Application no: **3/2021/0960**

Address: **2 Dunster Grove Clitheroe Lancashire BB7 2QL**

Proposal: **Proposed single storey pitched roof side extension and removal of garage. Remodelling works to create a new front entrance.**

The Local Highway Authority have viewed the plans and highway related documents and have the following comments to make:

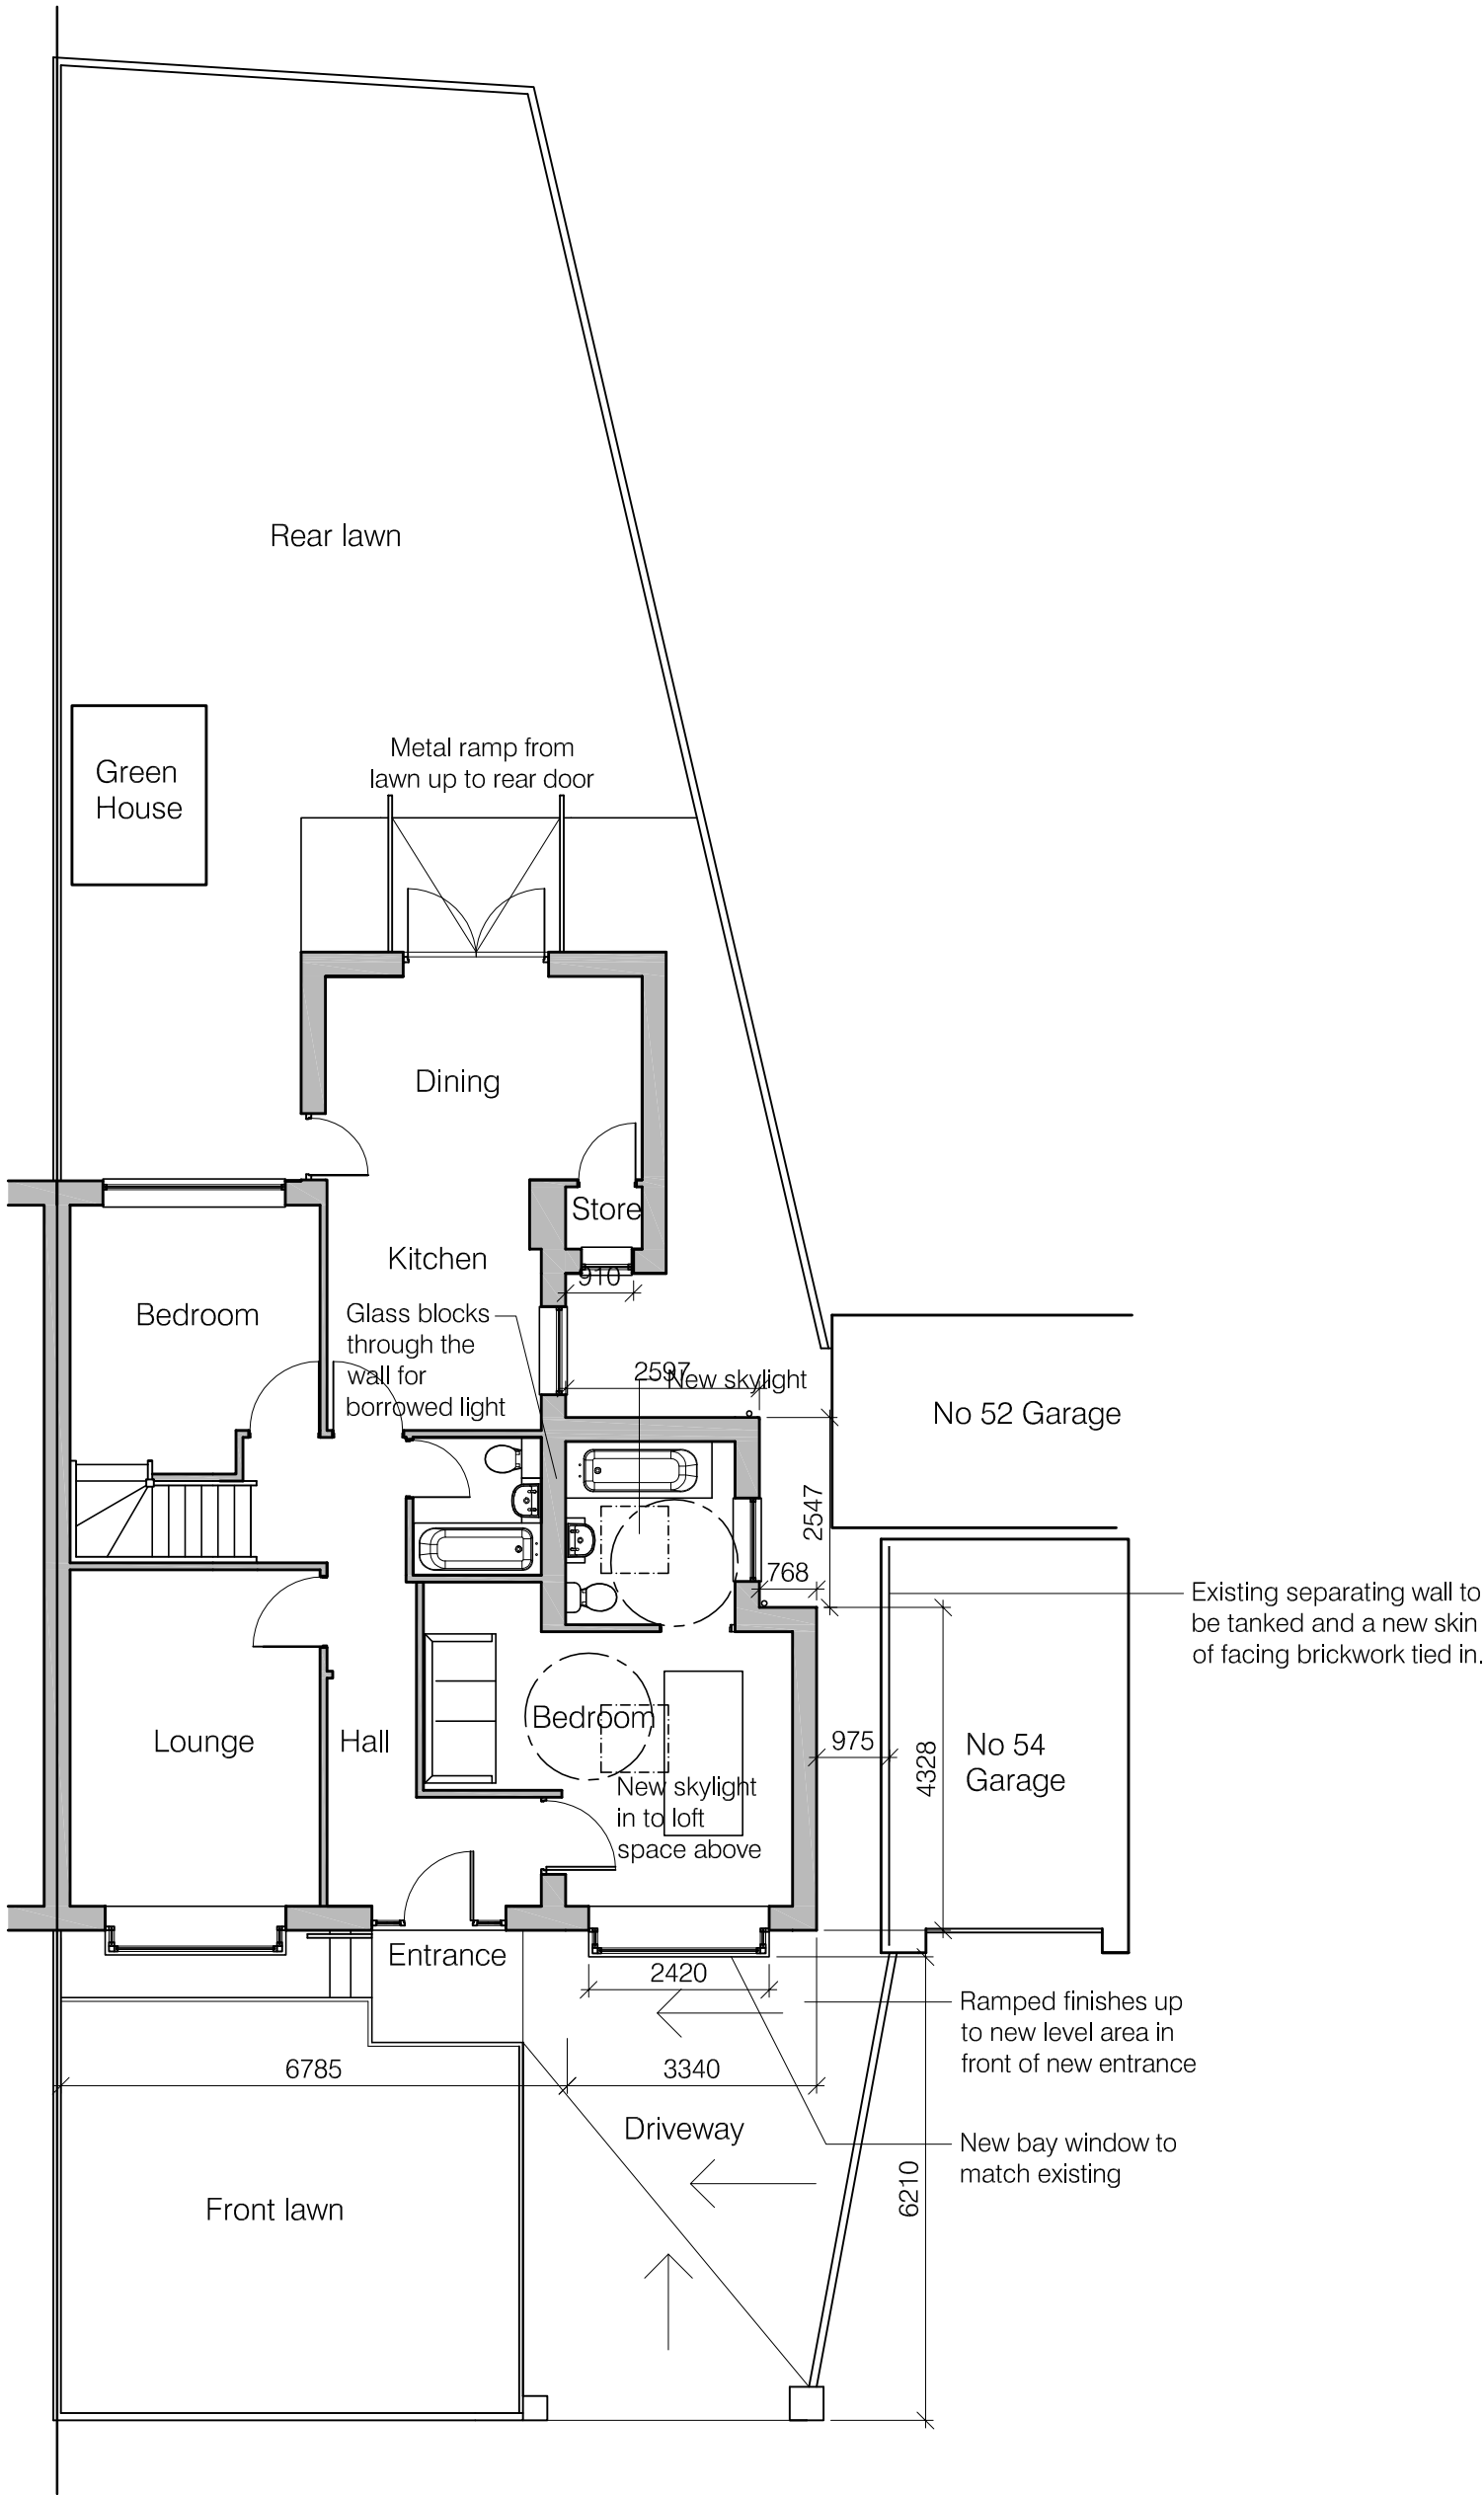
The LHA have reviewed the current proposal and understands that the existing access will remain the same following the proposal. The dwelling will also remain a 2-bed dwelling.

The LHA remind the Applicant that a 2-bed dwelling is required to provide 2 car parking spaces to comply with the guidance contained in the Joint Lancashire Structure Plan.

However, the dwelling is only able to provide 1 car parking spaces with it being located on the driveway following the removal of the garage. Therefore, there is a shortfall in one car parking space.

Notwithstanding this the LHA will accept the shortfall in one space at the dwelling. This is because whilst this is not ideal the LHA would not advise refusal of an application based on a shortfall of one parking space.
